Town & Country Planning Act 1990 (as amended)
Town & Country Planning (Development Management Procedure) (England) Order 2015

Demolition of existing garage & outbuildings. Alterations to external materials (including change from thatch to clay tiled roof and brick/stone to fibre cement weatherboarding and coloured render). Alterations to existing fenestration, including to 2 no. ground floor rear bay windows, and addition of first floor front dormer, enlarged balcony at first floor level at the rear. Replacement garages.

The Breakers 29 Tamarisk Way East Preston

Thank you for your internet representation made on 7th February 2020 which has been recorded as **'an objection'** with the comments as follows:

Elevations as Proposed

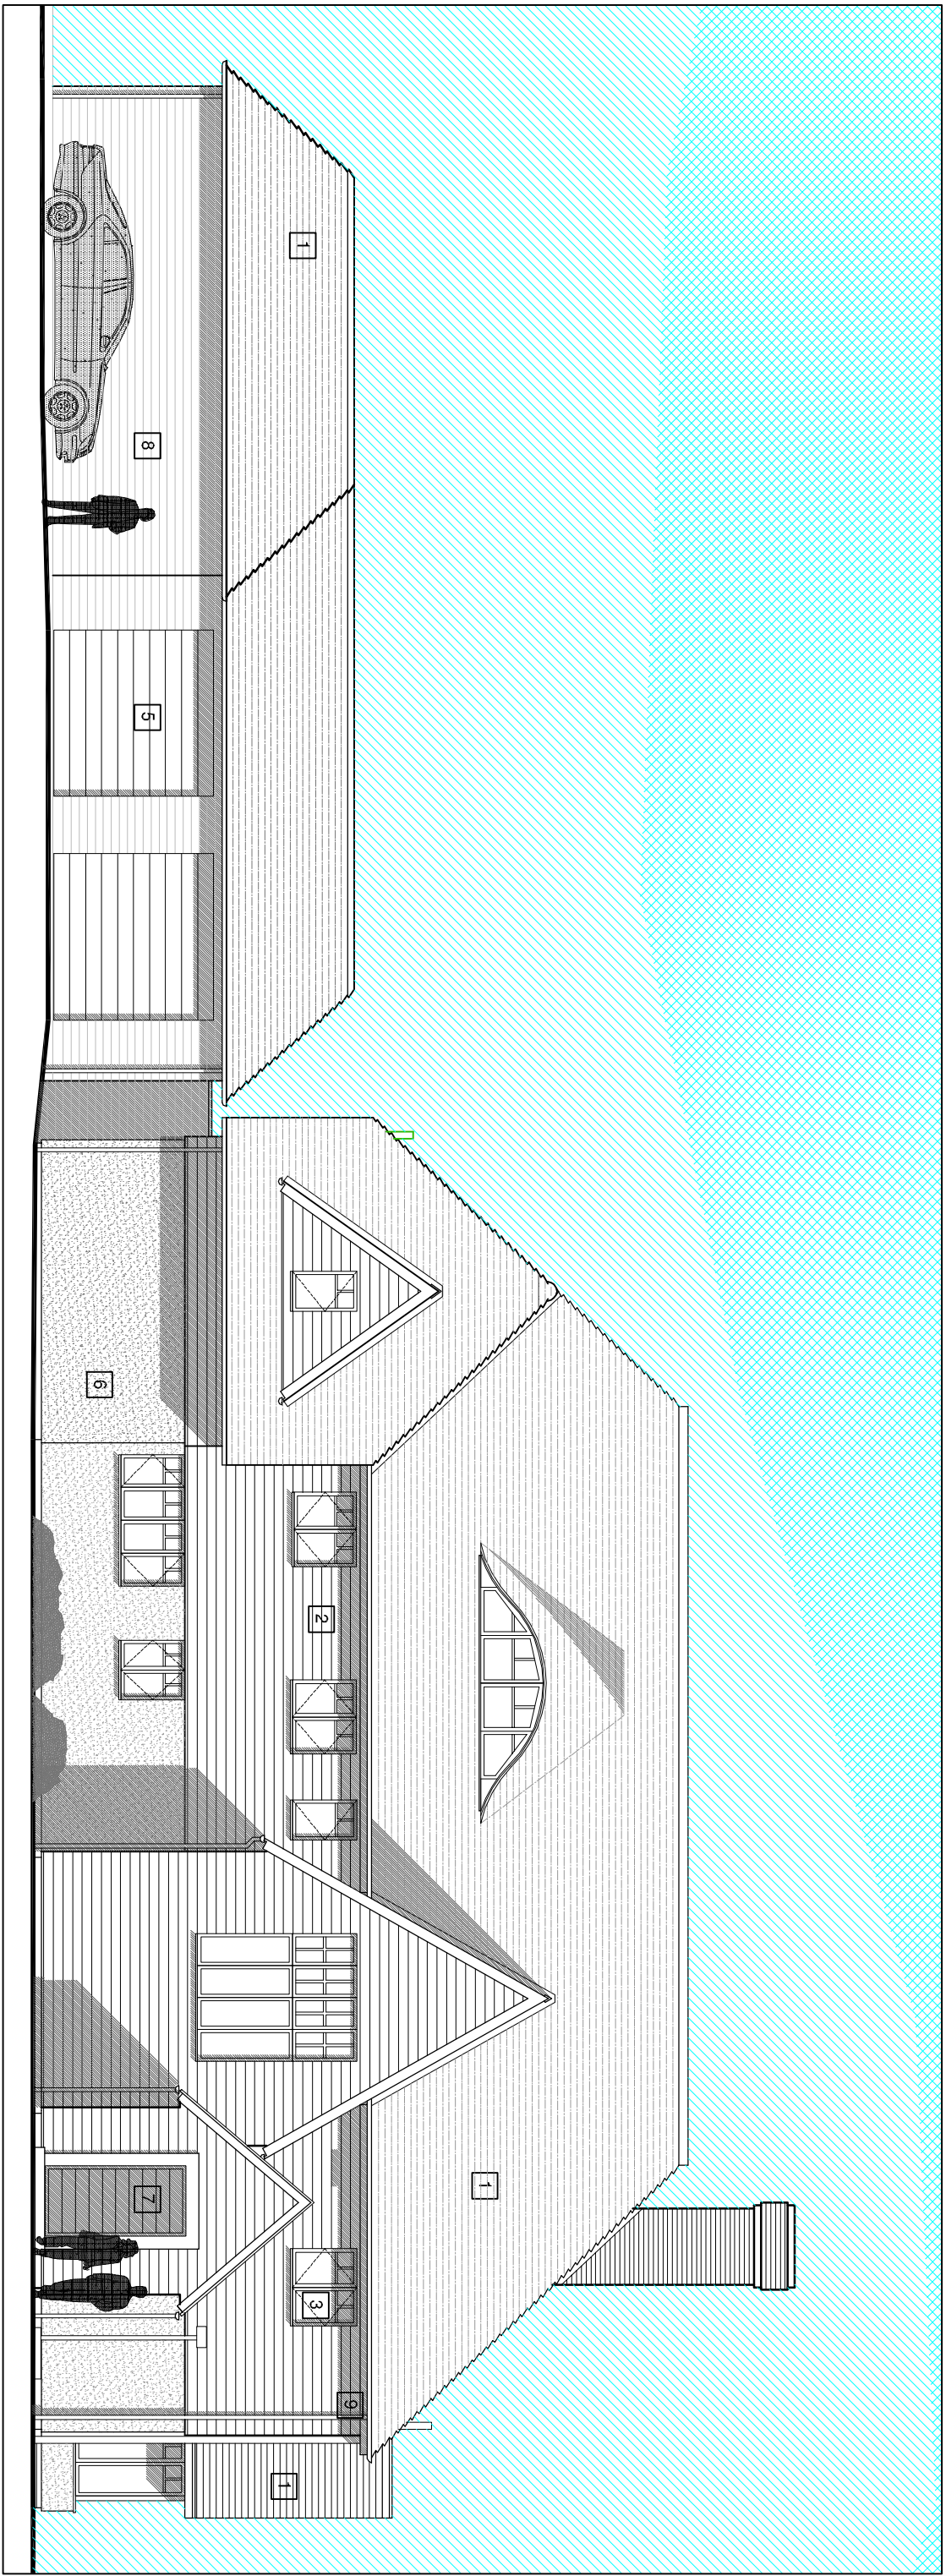
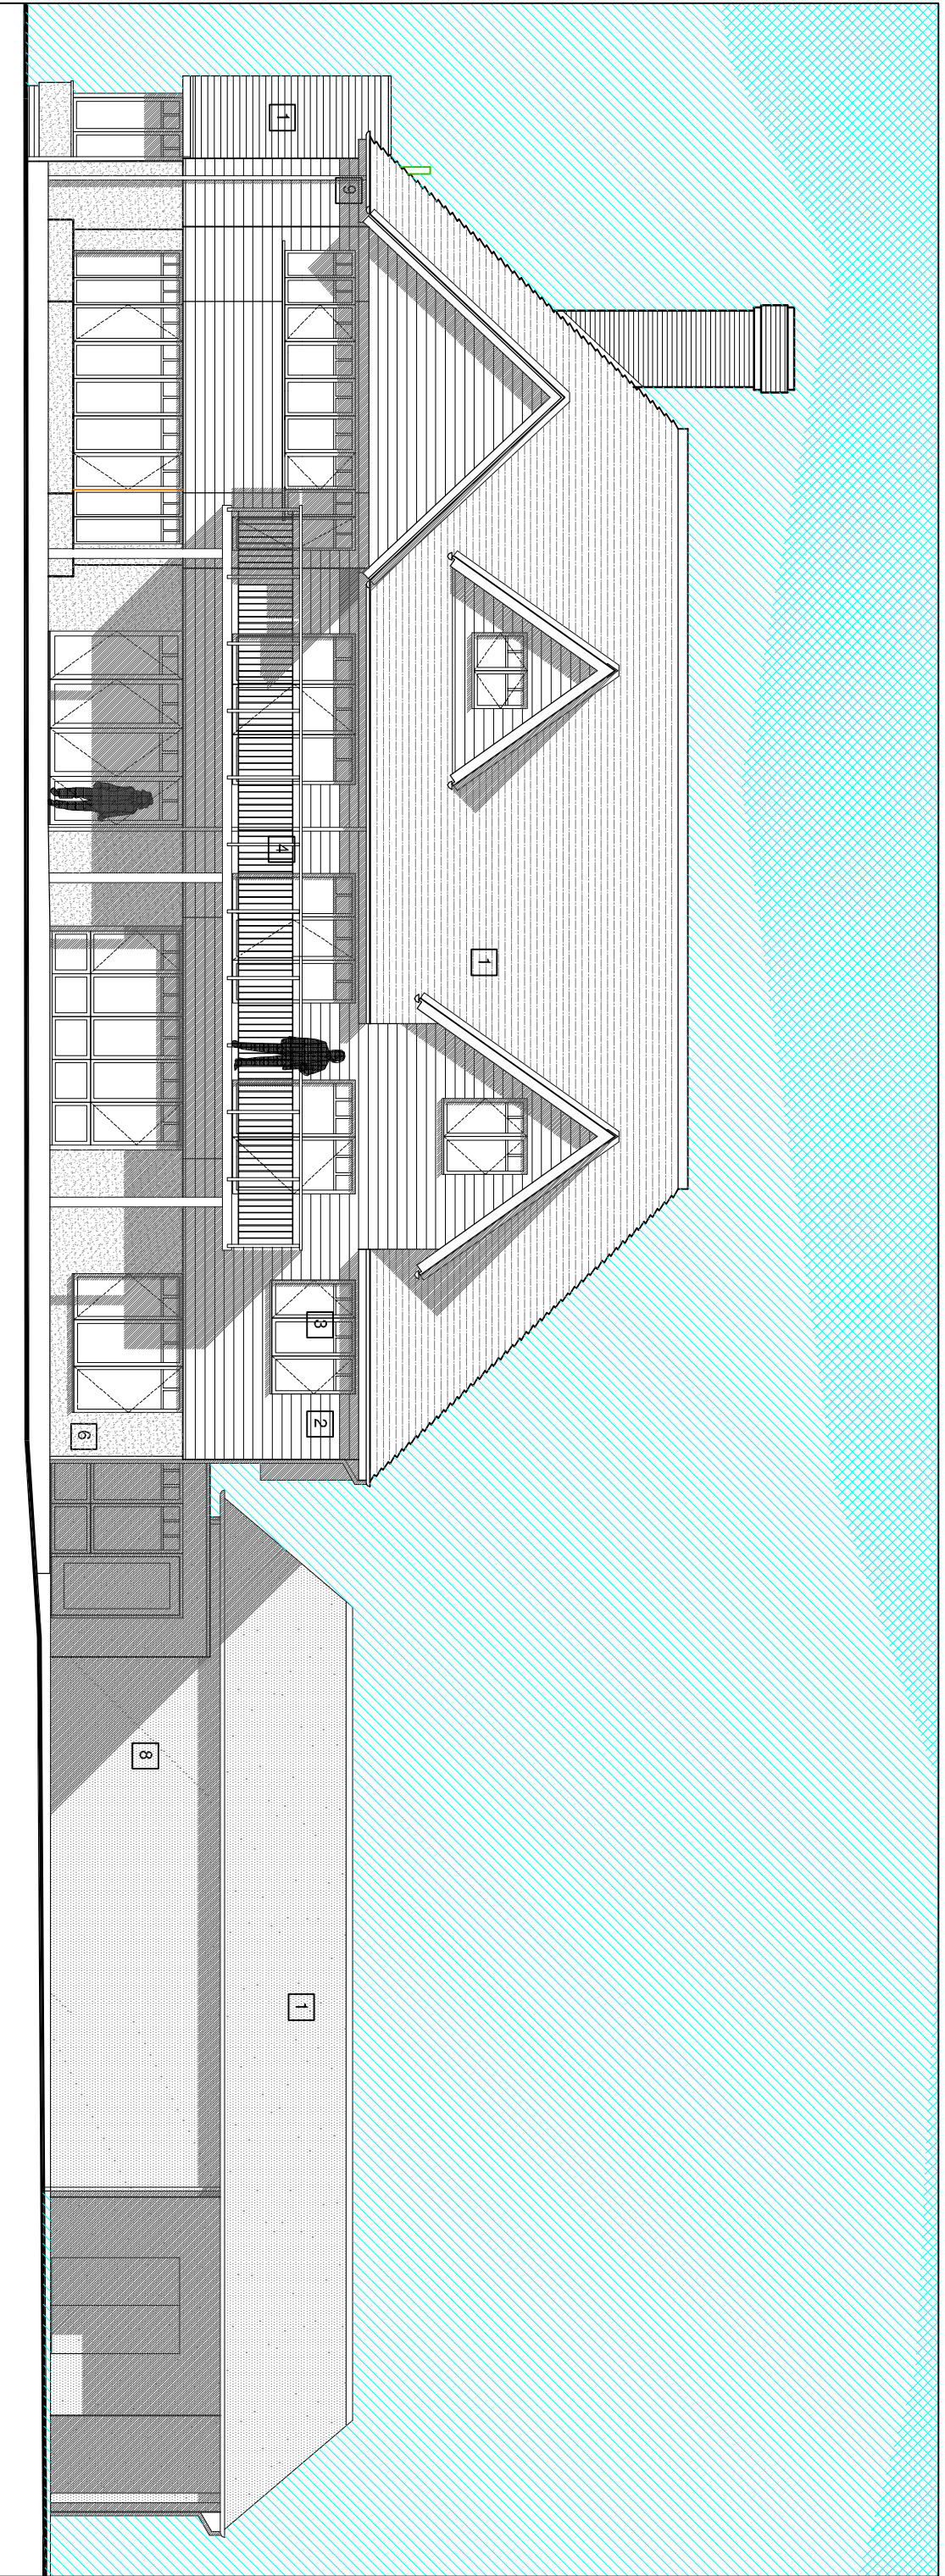
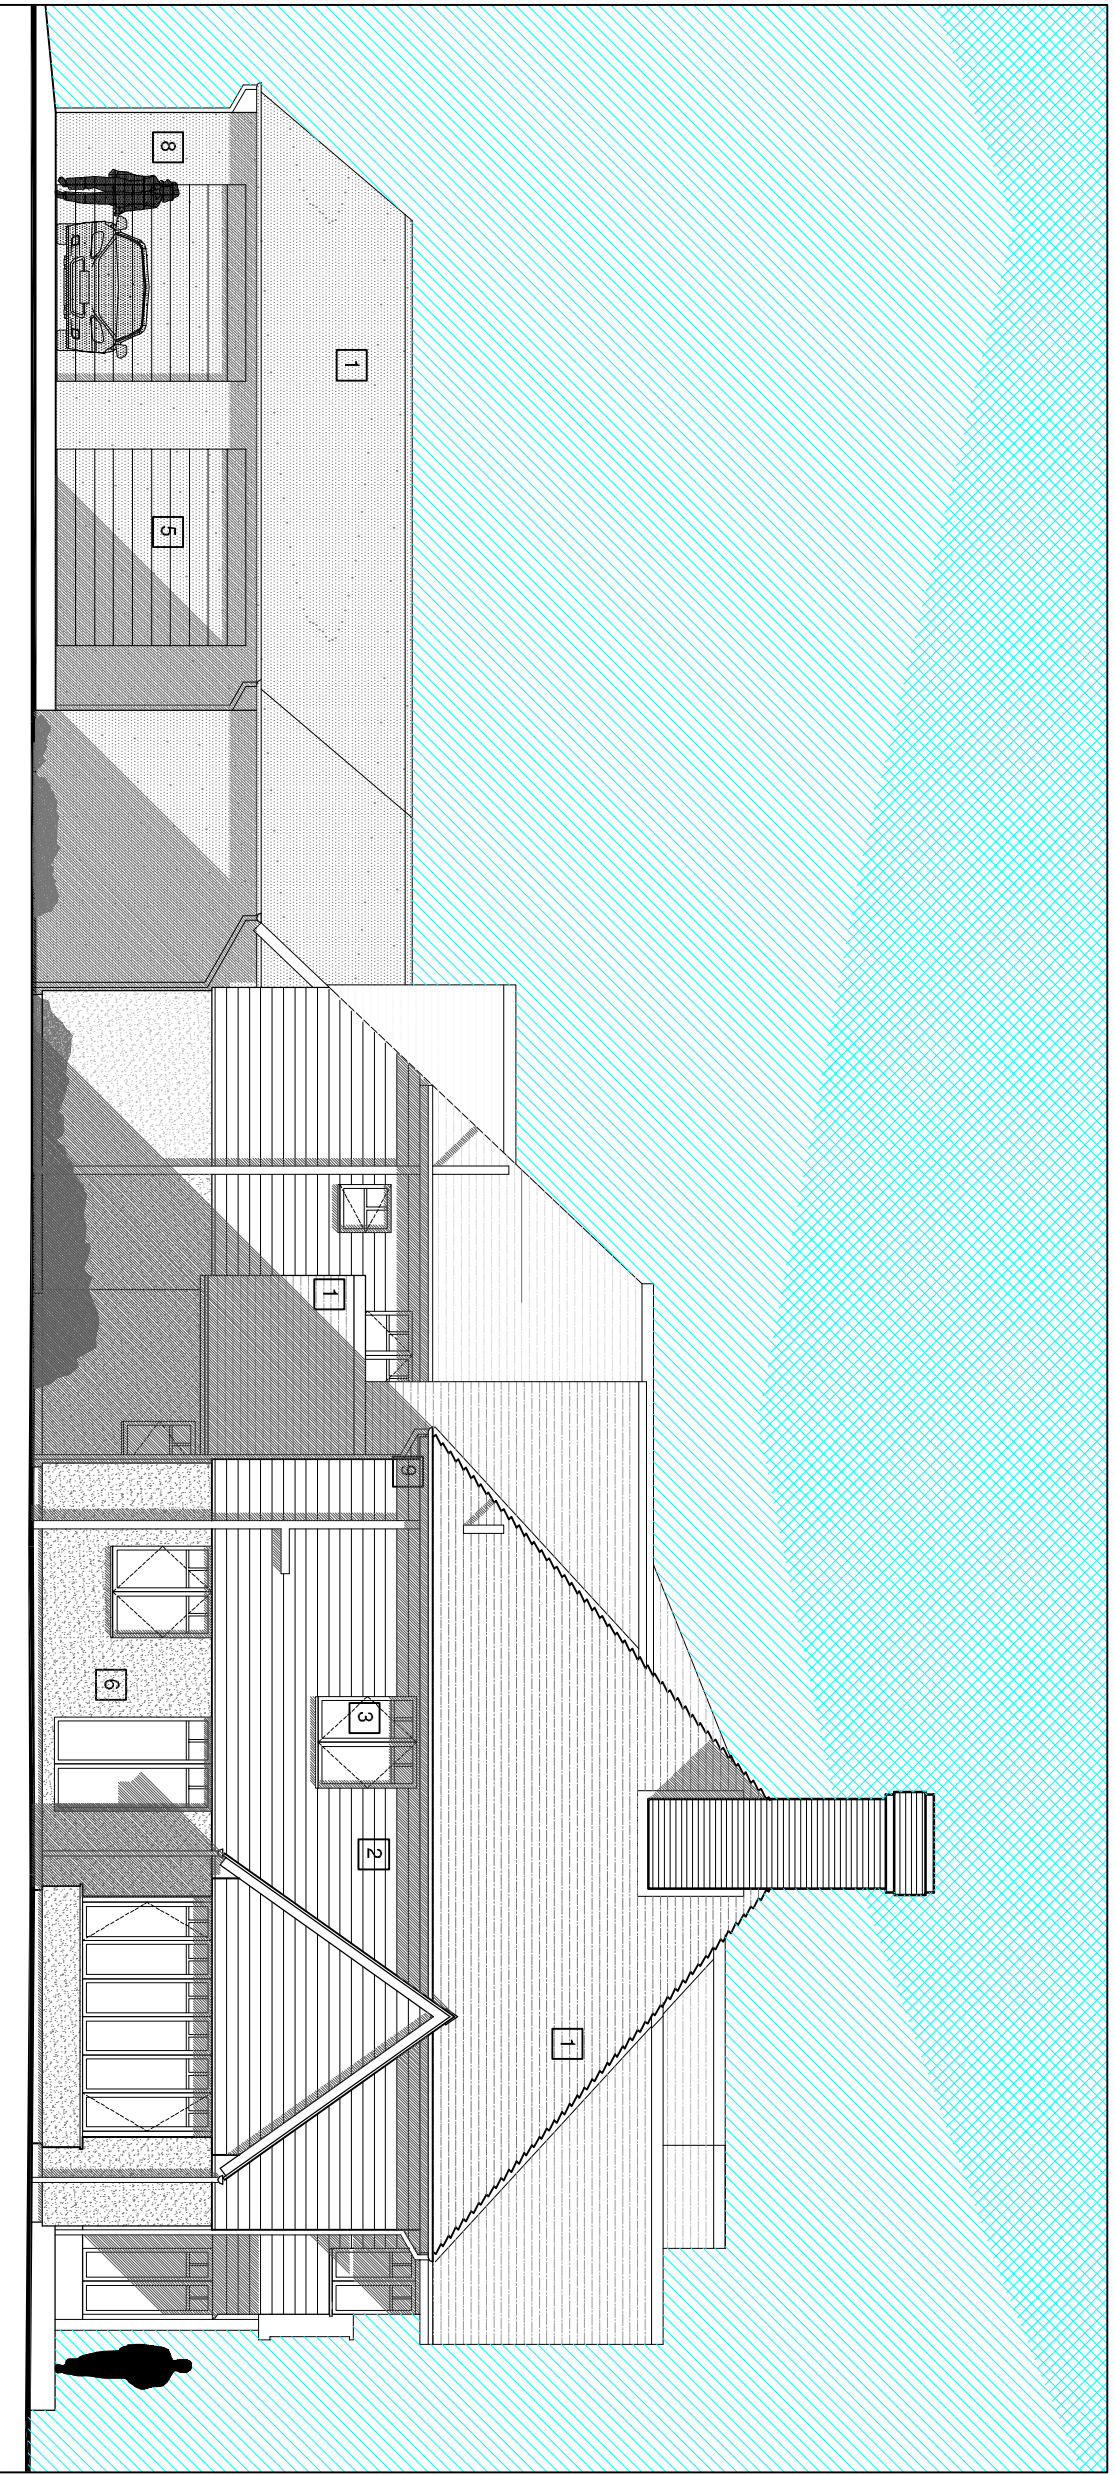
This proposal will destroy the character, not only of number 29 but the western end of Tamarisk Way as well.
